# 100% CONSTRUCTION DOCUMENTS

## WOODMEN HILLS WASTEWATER STORAGE FACILITY

### TRACT K MERIDIAN RANCH FIL 1, EL PASO COUNTY, STATE OF COLORADO

Comments are provided on the CDs for informational purposes only. CDs are not required for this project because the disturbance is under an acre and because of the scope of work proposed. No resubmission request will be sent for the CD package. See comment on page 6 regarding the sheets that sheets that are not a part of the CD submittal.

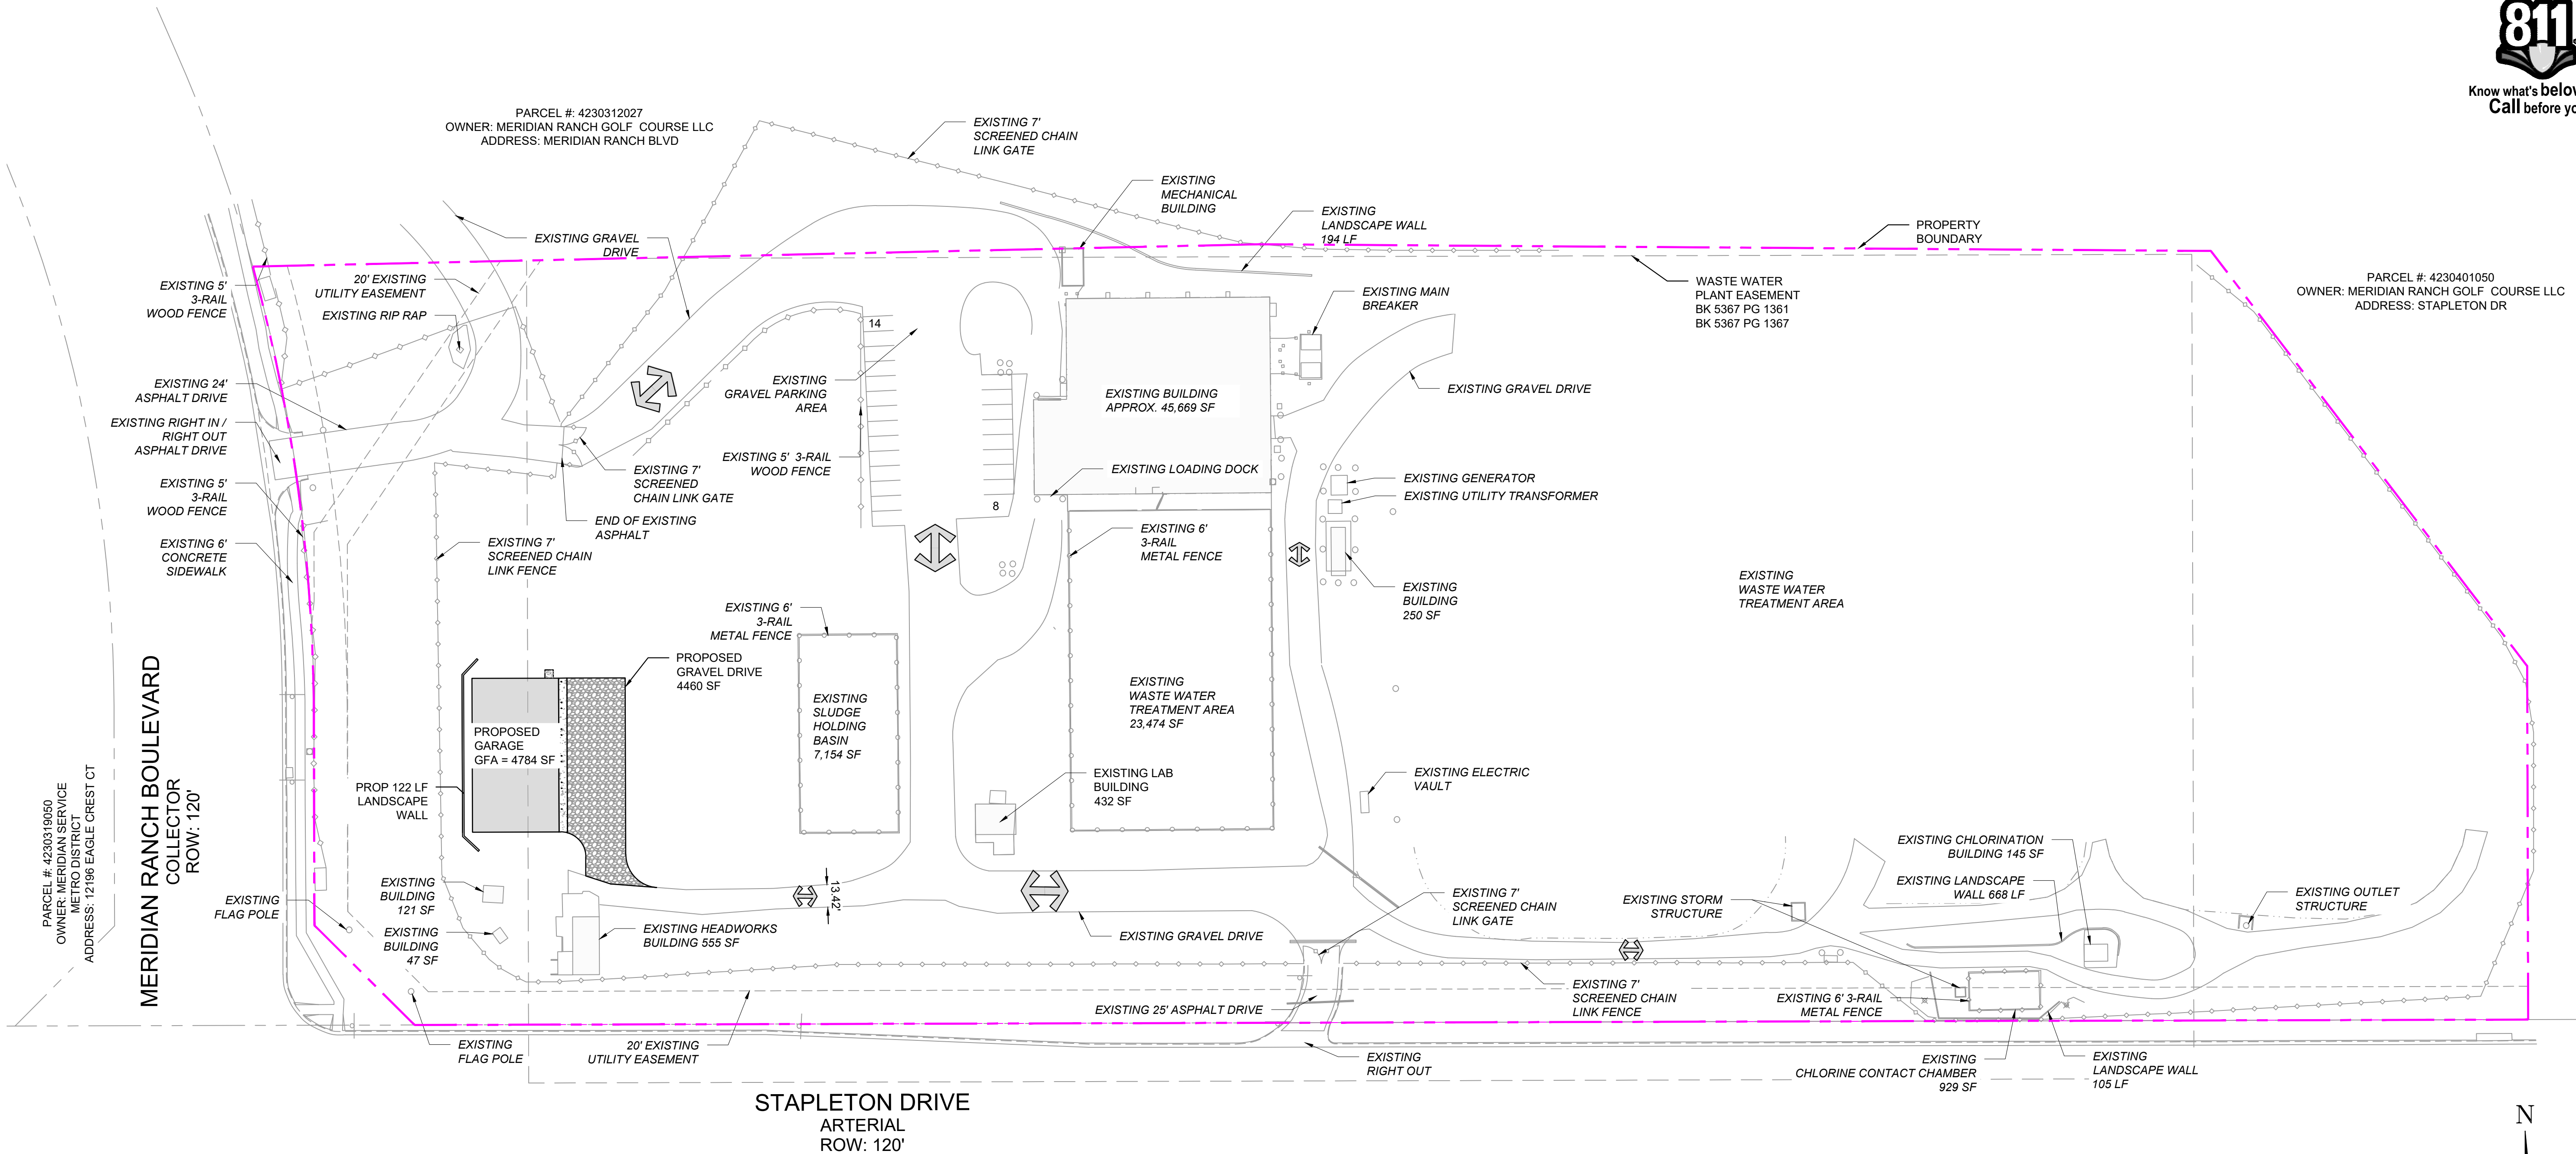
the radii will not accommodate the Falcon Fire apparatus  
Per Falcon Fire's uploaded letter this road shall be no less than 20' width

WOODMEN HILLS WASTEWATER					
WOOMEN HILLS METRO 100% CONSTRUCTION DOCUMENTS					
DETAIL GRADING PLAN					
DESIGNED BY: MDF	SCALE: HORIZ. 1" = 10'	DATE ISSUED: JUNE 2025	DRAWING No. GR01		
DRAWN BY: KGI	VERT. N/A	SHEET 5 OF 8			
CHECKED BY: MDF

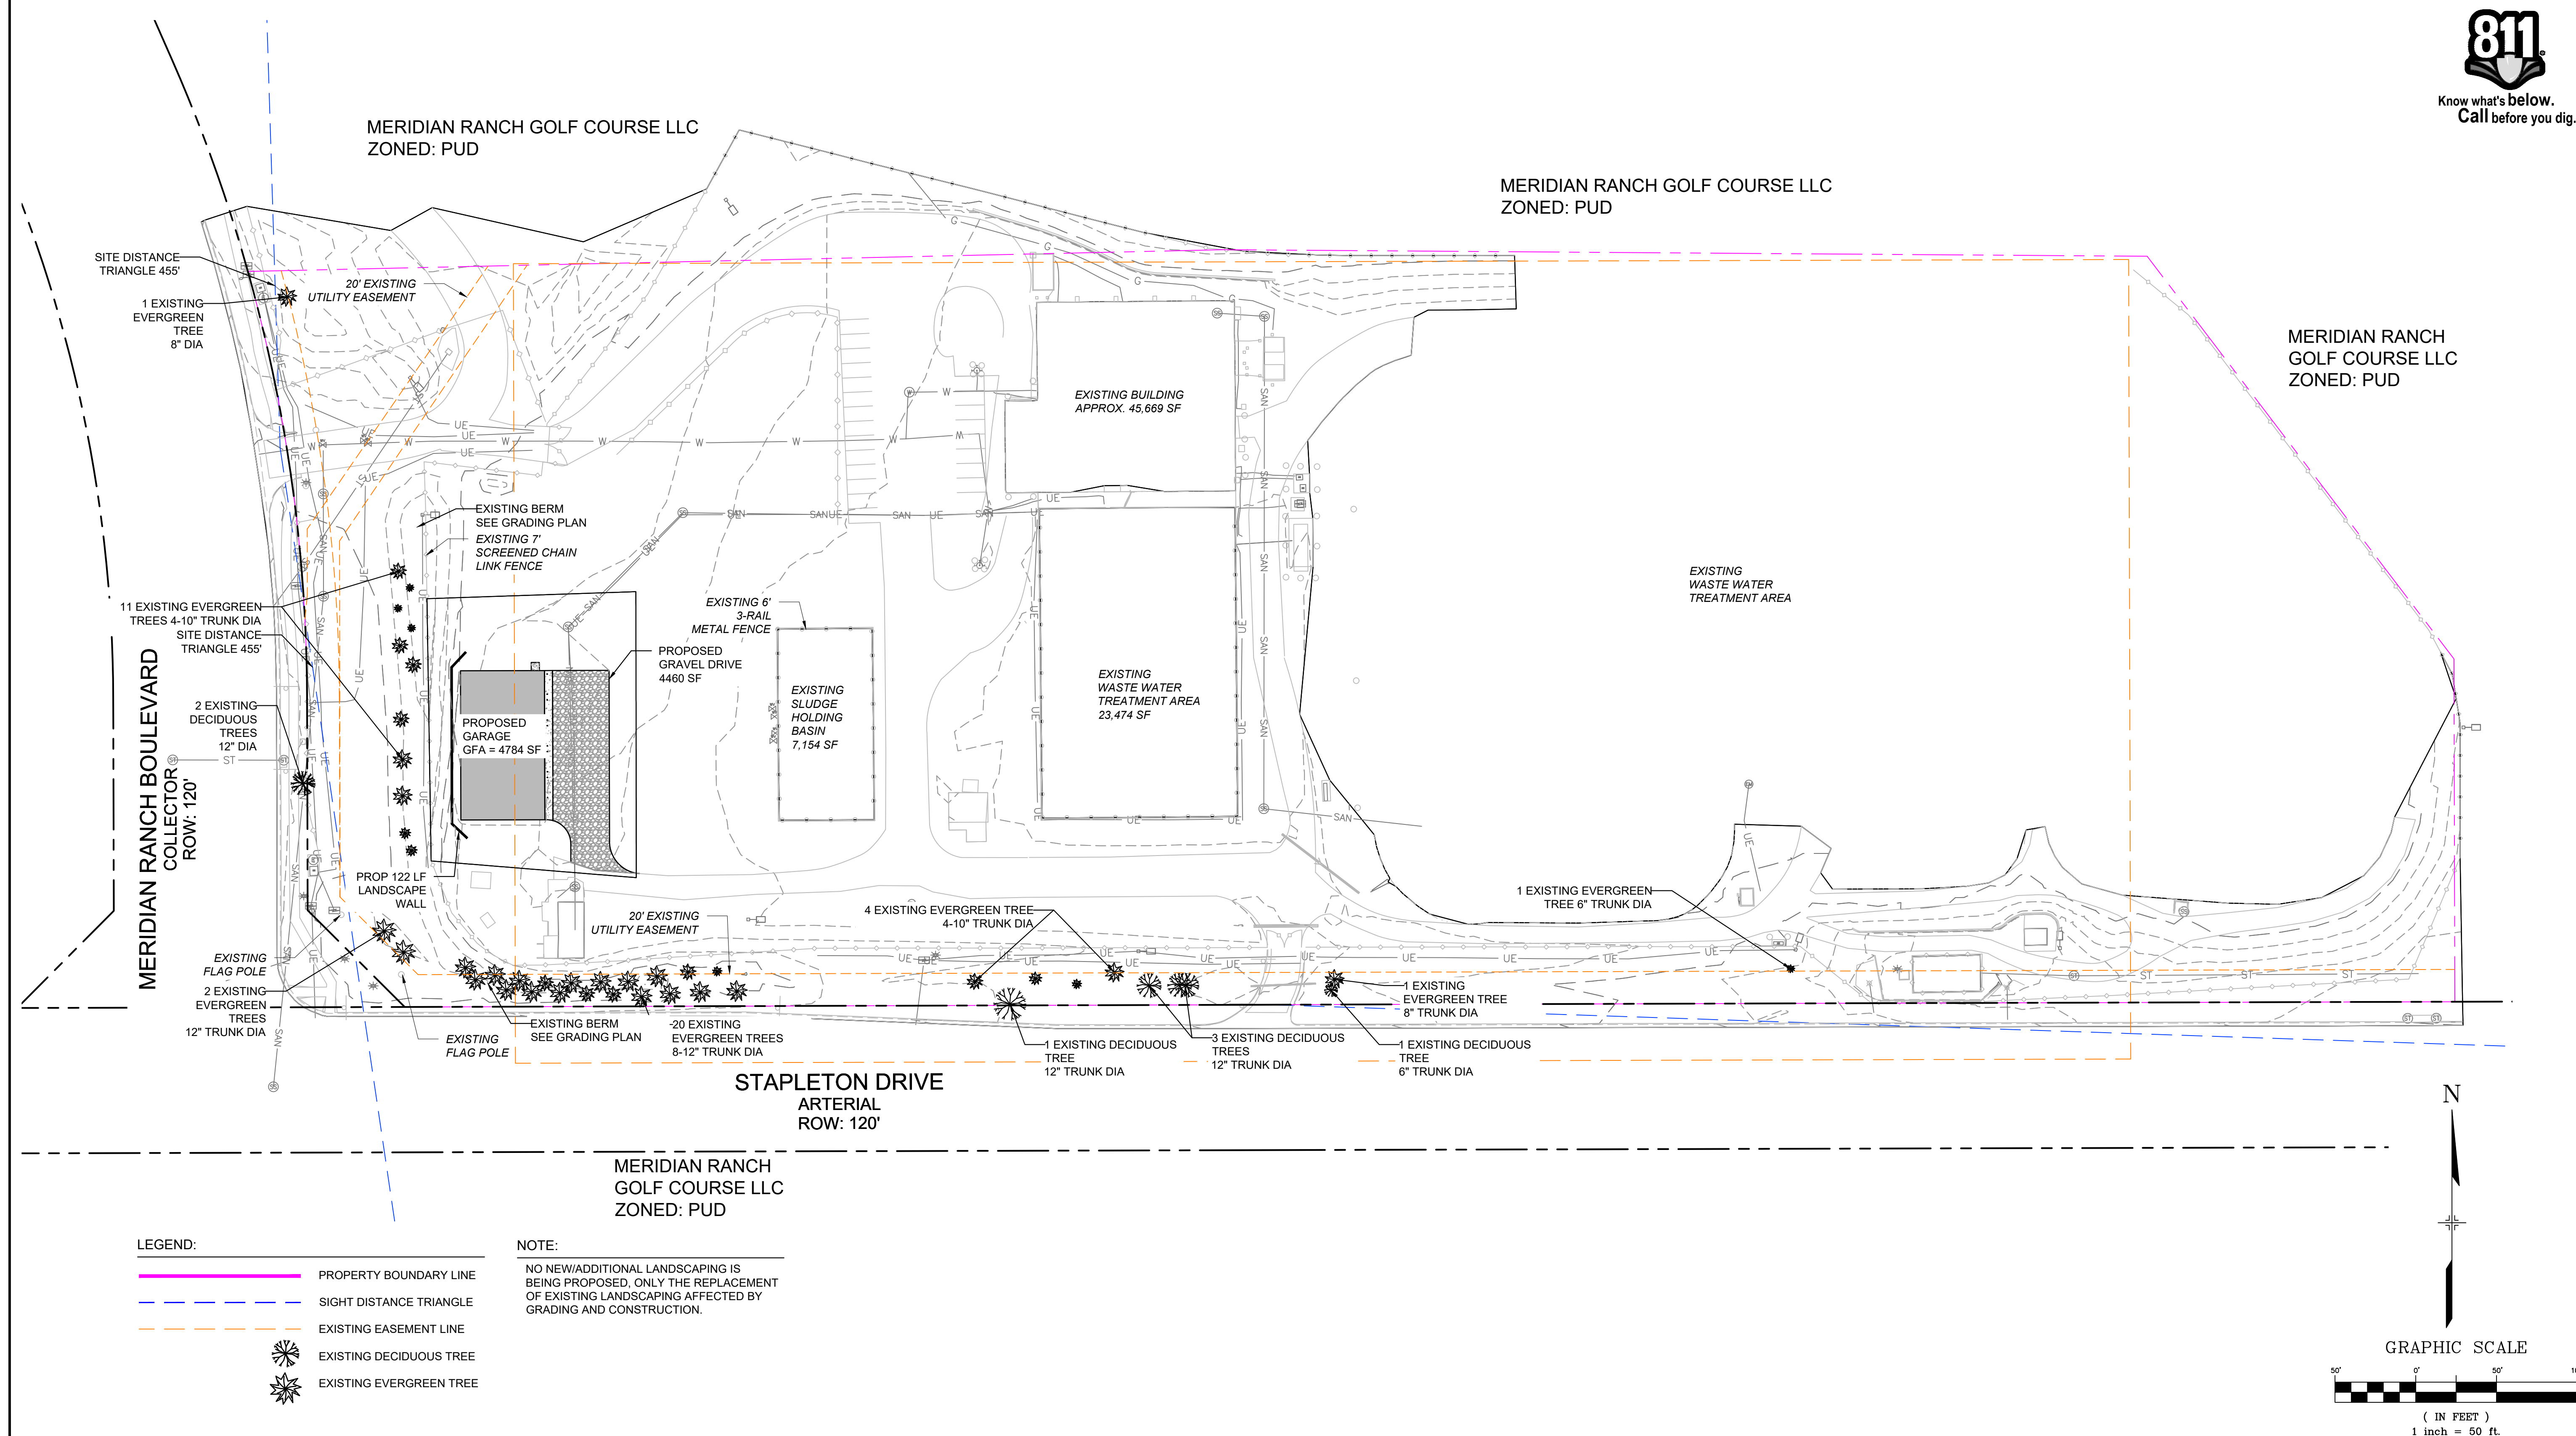
Grading doesn't match what is shown on the drainage letter.

Based on what is shown for grading, it appears that the grading may be directing this flow to the south of the site instead of to the east.

WOODMEN HILLS WASTEWATER			
WOODMEN HILLS METRO 100% CONSTRUCTION DOCUMENTS			
LANDSCAPE PLAN			
DESIGNED BY:	MDF	SCALE:	DATE ISSUED:
DRAWN BY:	KGI	HORIZ:	JULY 2025
CHECKED BY:	MDF	VERT:	SHEET
			6 OF 8
DRAWING No.			LS01

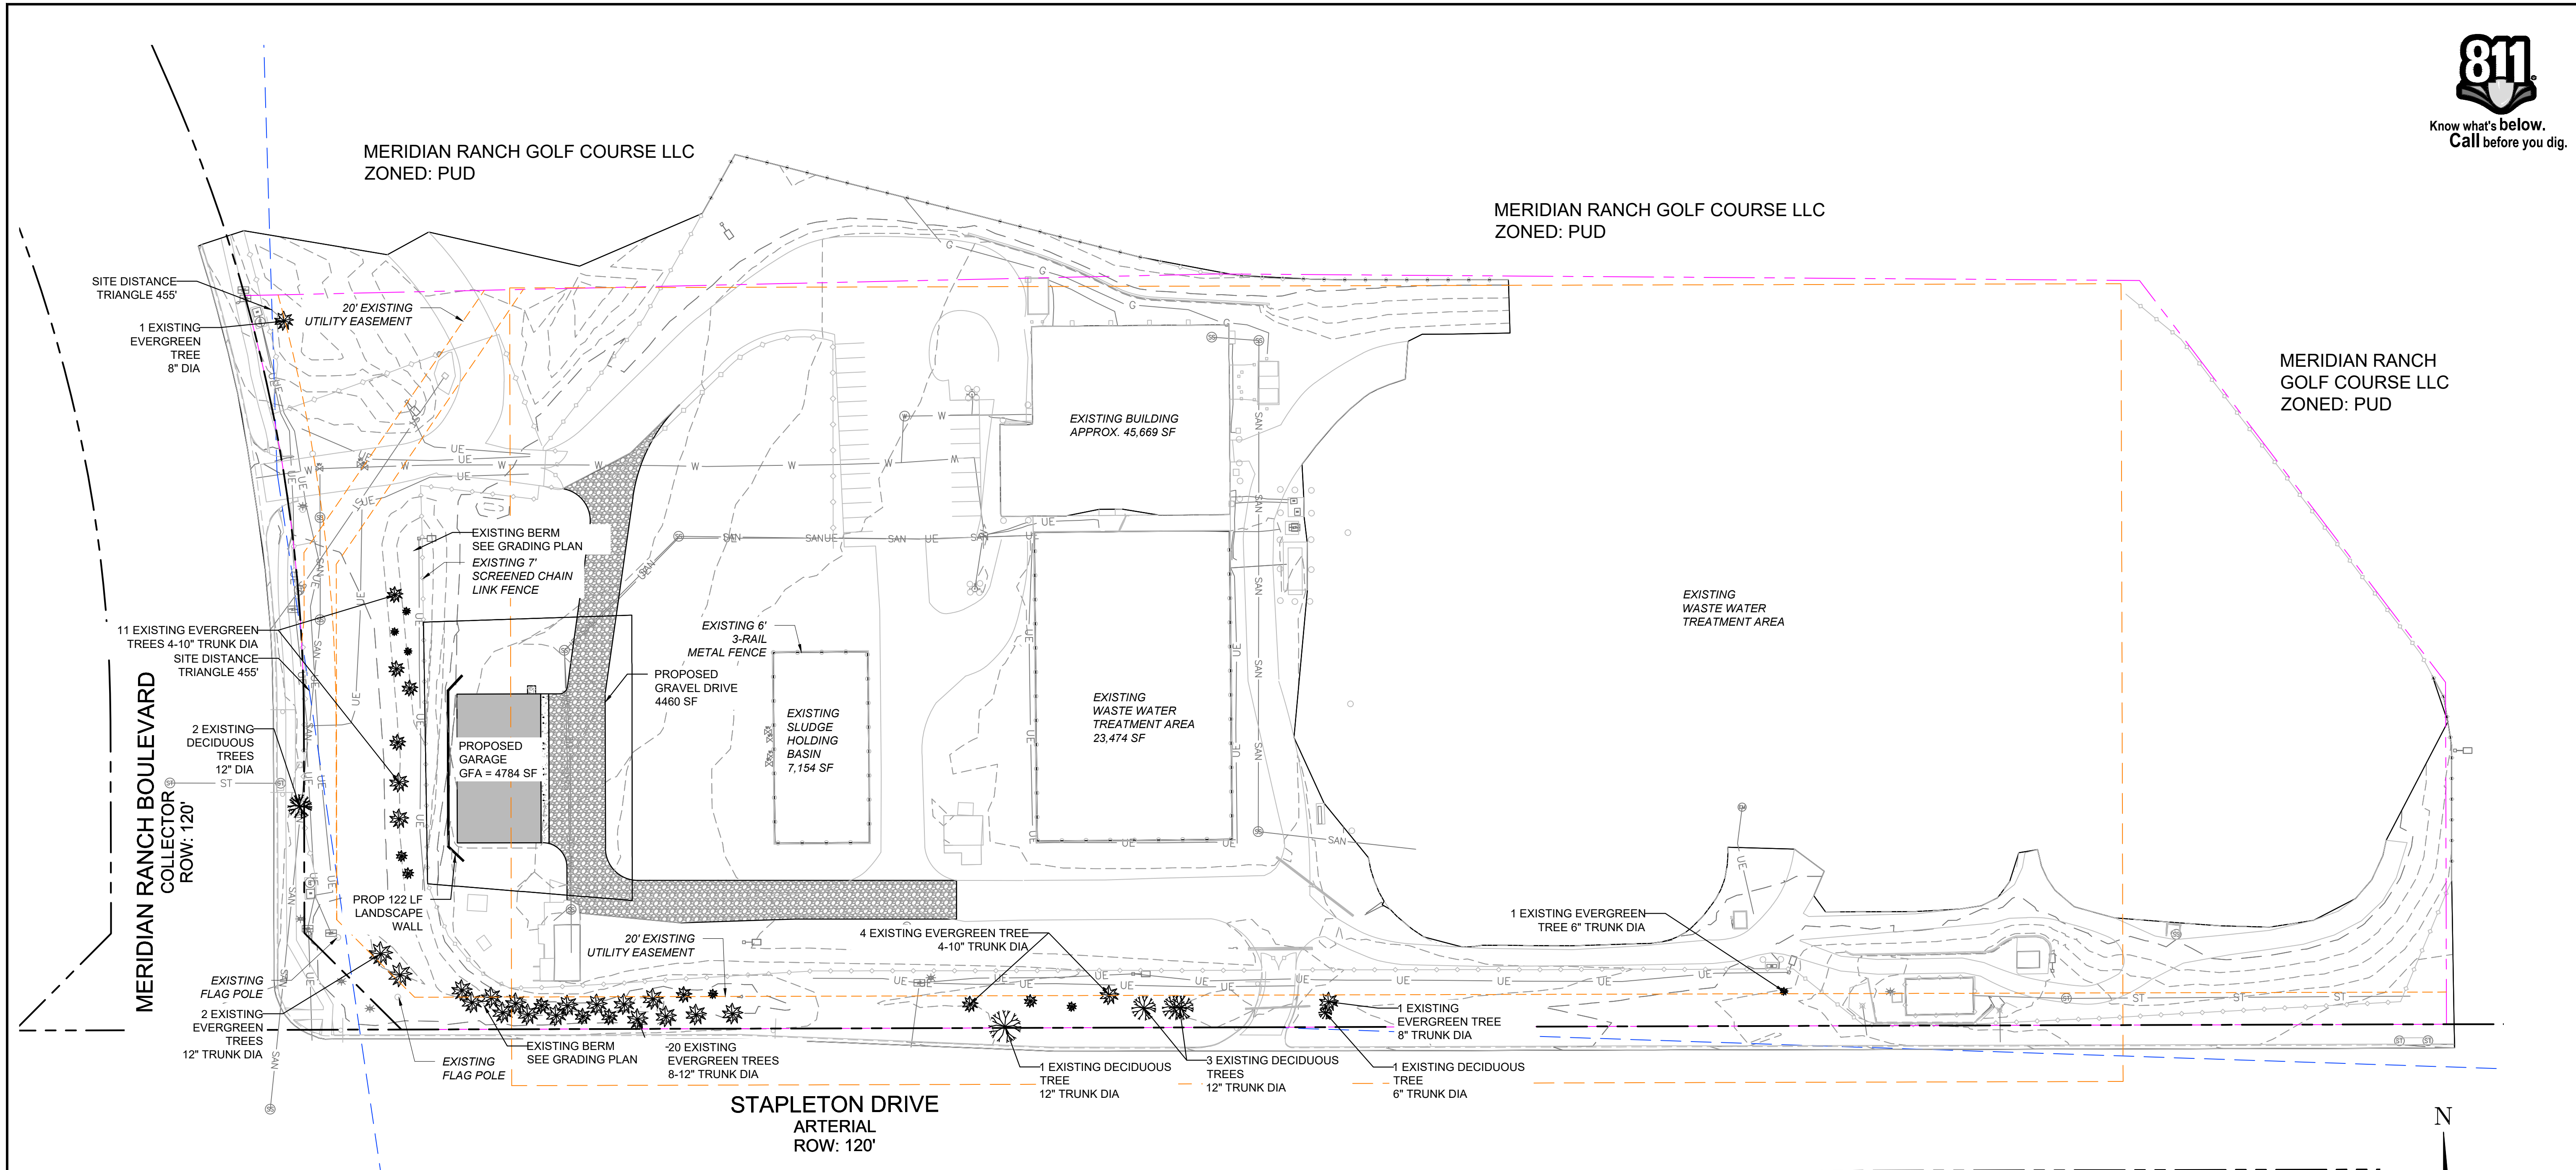
These lines not in legend. Consider removing.

Doesn't match drawing.
